**HUNTER VALLEY OPERATIONS SOUTH MP 06\_0261 MOD 5  
RESPONSE TO SUBMISSIONS**

**ENVIRONMENT PROTECTION AUTHORITY – REVIEW OF RESPONSE TO SUBMISSIONS  
MP 06\_0261 MOD 5  
HV OPERATIONS PTY LTD**

Figure 5: Times series plots comparing predicted 24-hour average PM10 impacts at Assessment Location 309 without (above) and with (below) reactive measures during Stage 3

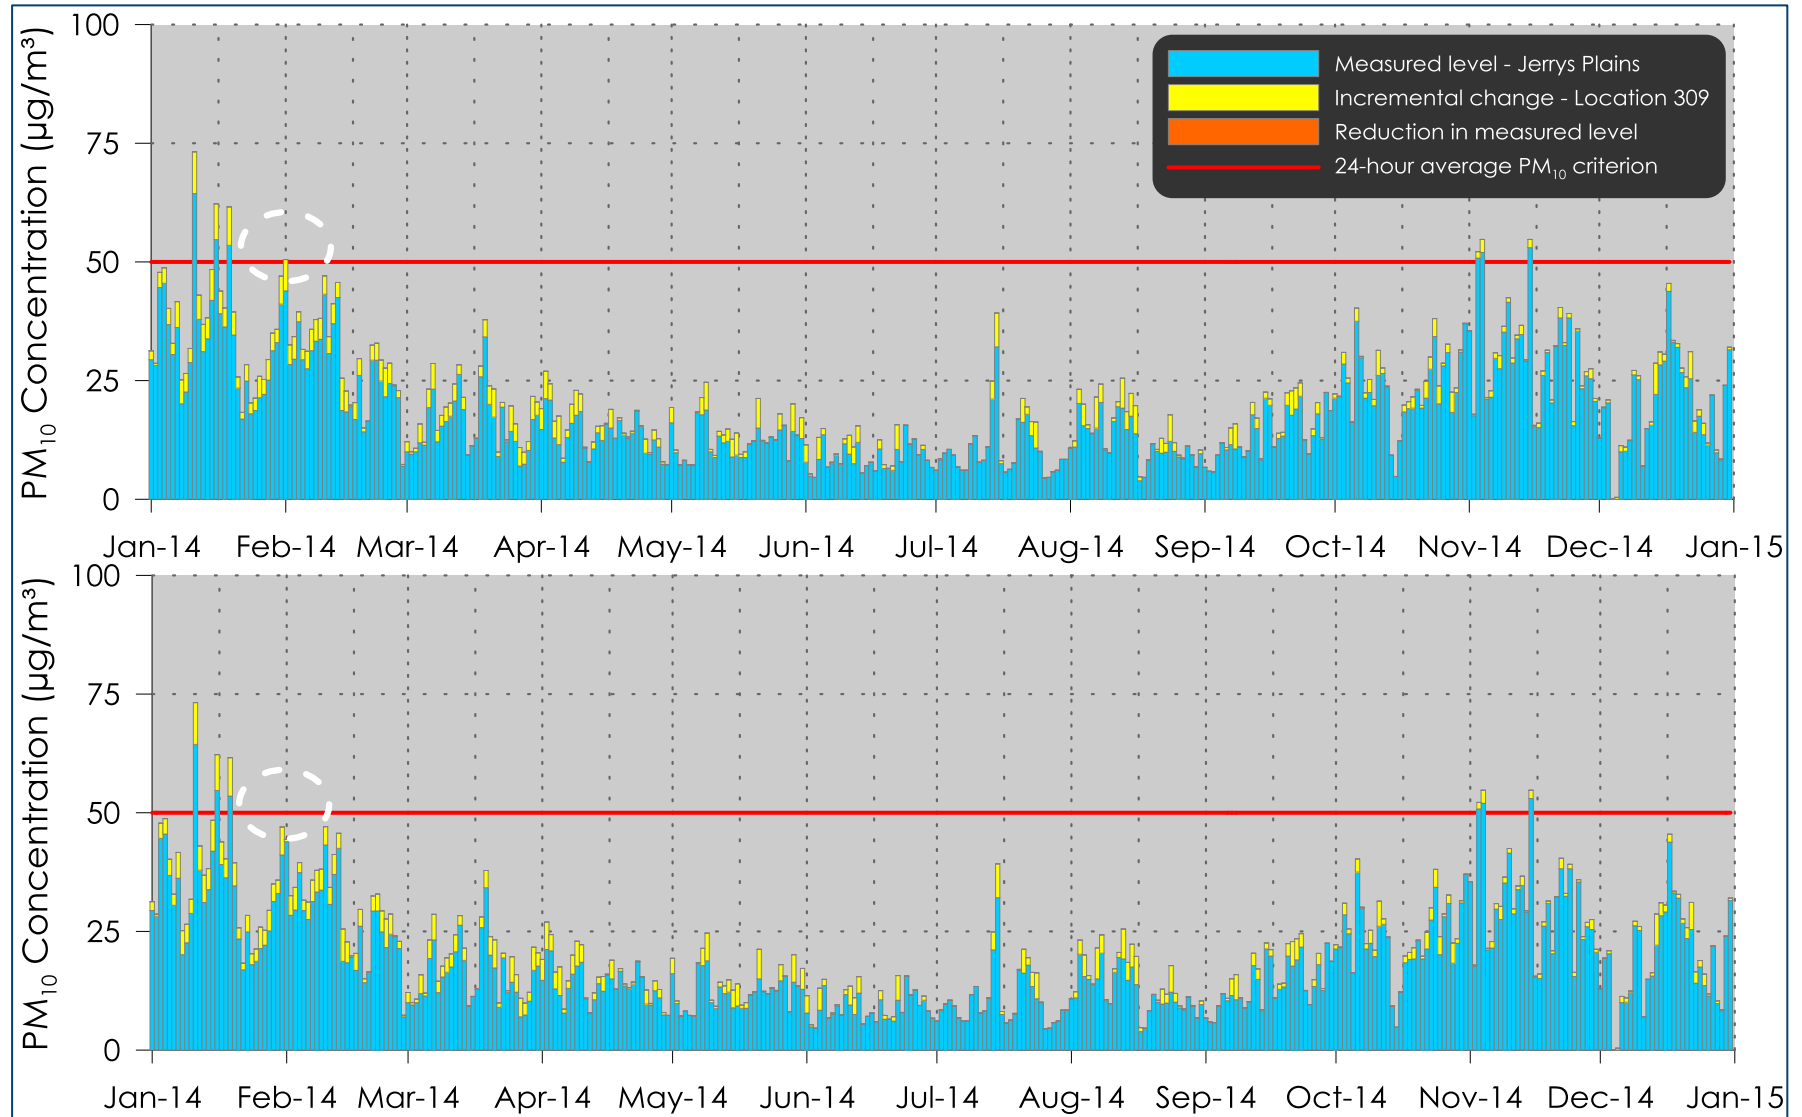
The RTS has stated the intended approach to mitigating the assessed additional exceedences of 24-hour impact assessment criteria. There is no analysis indicating the effectiveness of the planning and reactive management systems. In particular, there is no direct estimate of the ability of the system to mitigate the assessed additional exceedence days.

Section 7.7 of the Approved Methods Modelling requires that where impact assessment criteria are exceeded, additional mitigation measures must be assessed until compliance is achieved. To meet this requirement, evidence needs to be provided that the proposed management actions remove the additional exceedences of impact assessment criteria.

The EPA requires assessment showing that the proposed reactive management successfully identifies the additional exceedences and reduces emissions sufficiently that the exceedences do not occur.

It is clear that the real-time air quality management system is used. The performance of the system has not been shown. As set out above, to meet the requirements set out in section 7.7 of the Approved Methods Modelling, assessment is needed showing that operation of the reactive management system removes the additional exceedence days occurring without it.
